February 18, 2015

re: objection-public comments on Grow Bros Permit applications (BP-14-00772, BP-14-00800 through BP-14-00806) and related SEPA checklist

ENLARGED SITE PLAN

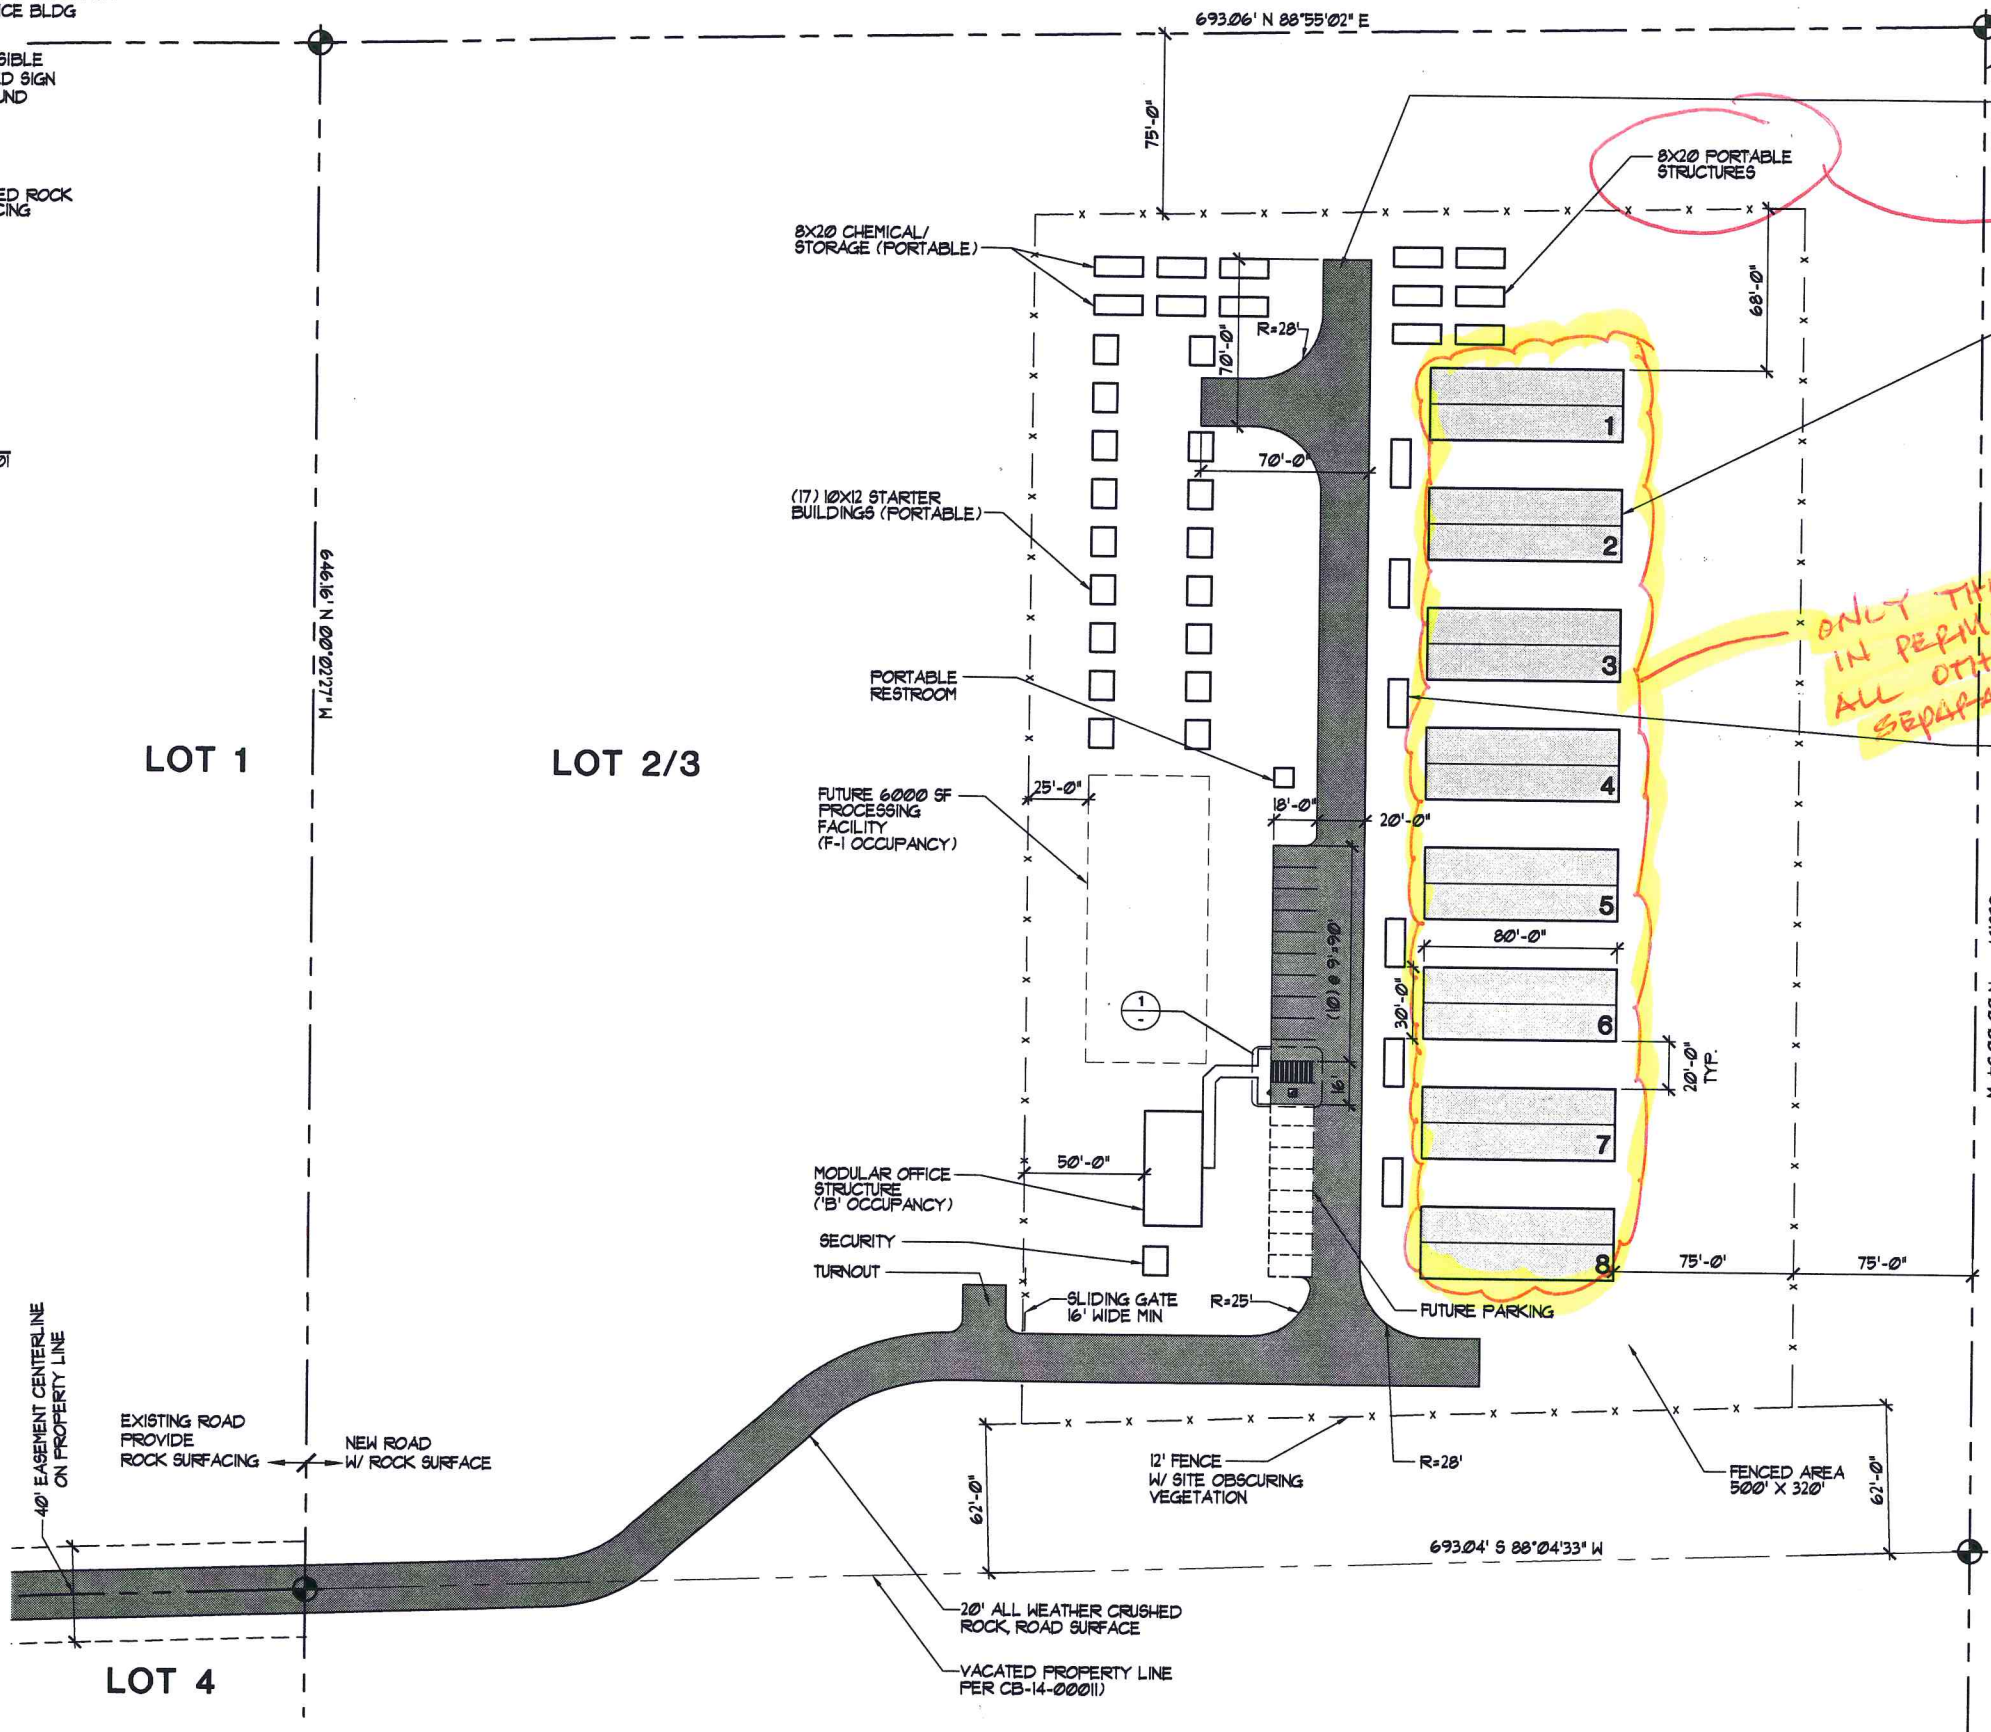
These permits are incomplete and references to future plans noted in SEPA documents and site plans, all do not vest.

And because the applicant appears to be attempting to vest further expansions with the references to these in submitted paperwork, I will also address the fact that the inclusion of references to additional phases and future plans in the submitted paperwork is essentially irrelevant for anything other than SEPA analysis and for some indication of what is required for adequate water and sewer facilities.

Because the building permits are not complete and valid, they do not vest under the prior land use ordinances, and because of the change in marijuana rules, they are not allowable under current codes. Also, under the circumstances presented, any references to future expansions on site plans and SEPA documents do not provide any authority for any vesting for any requested future authorizations.
